# CITY OF ALBUQUERQUE

**Re: Natural Grocers FINAL TIS**  
**4625 Wyoming Blvd. NE**  
**Traffic Impact Study**  
Engineer's Stamp dated January 2, 2022 (HT#F19D013E)  
Received 1/2/2024  
CABQ Planning Transportation approval

The subject Traffic Impact Study (TIS) for the Natural Grocers final TIS 4625 Wyoming Blvd. NE dated January 2, 2024 received on January 2, 2024, has been reviewed by the Transportation Development Section and found acceptable. The TIS is approved with the following conditions.

\*Right-in/Right-out/Left-in Only

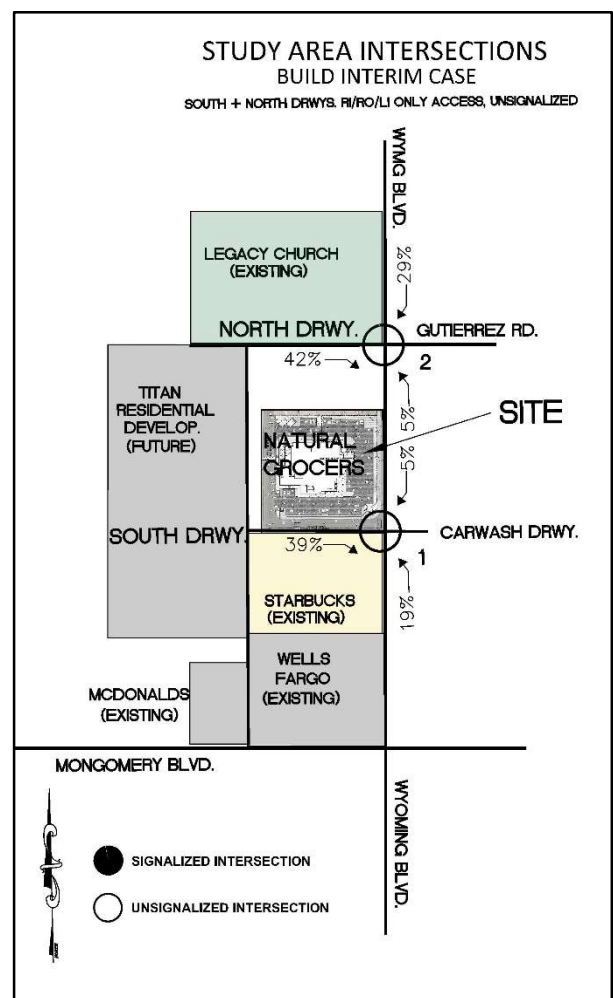
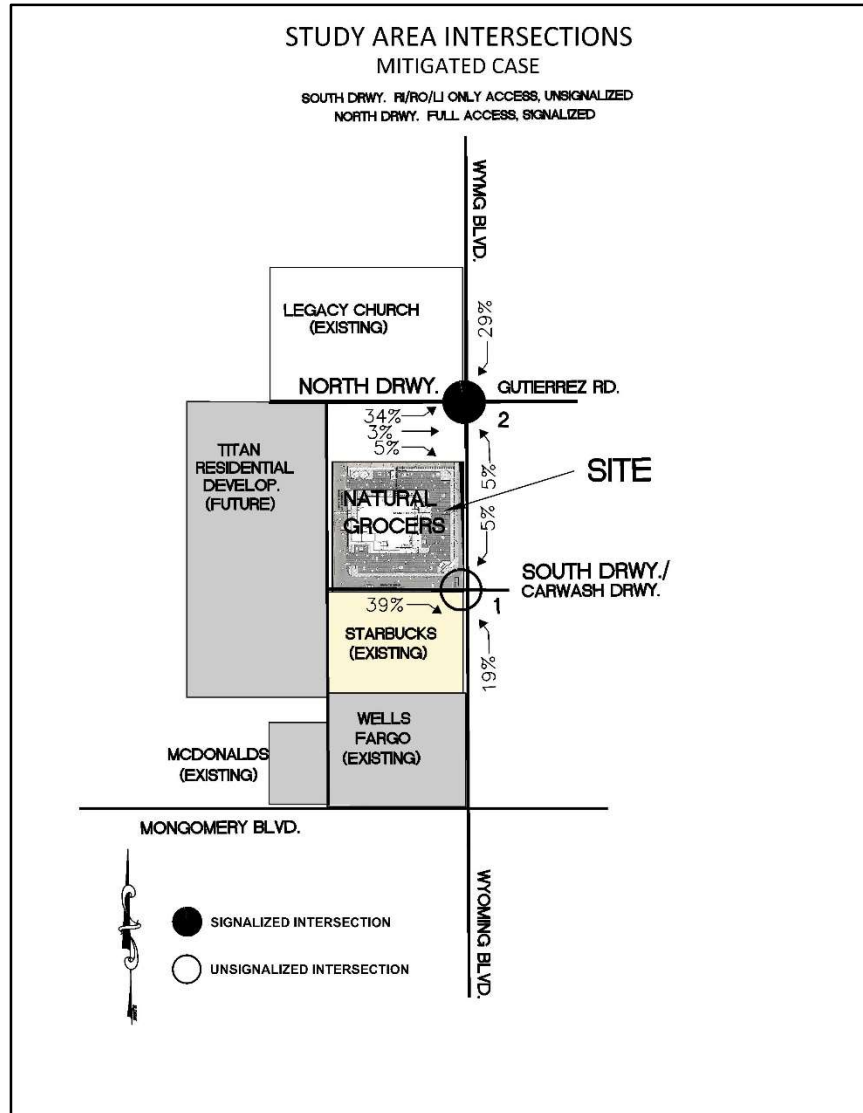
- The Natural Grocer's development shall use only existing driveways to access the Natural Grocer's site from Wyoming Blvd. and Montgomery Blvd.
- Intersection 1 (South Driveway & Wyoming Blvd.)

- The eastbound approach should be remarked, and a raised median should be constructed at the driveway entrance to restrict access to right-in/right-out/left-in only.

- Intersection 2 (North Driveway/Gutierrez & Wyoming Blvd.)
  - The eastbound approach shall be re-marked to indicate one dedicated eastbound left-turn lane and one eastbound thru/right lane.

- In the interim period, until the new signal can be constructed, it is recommended that the North Driveway be reconfigured as restricted access driveway (Right-in/Right-out/Left-in Only).
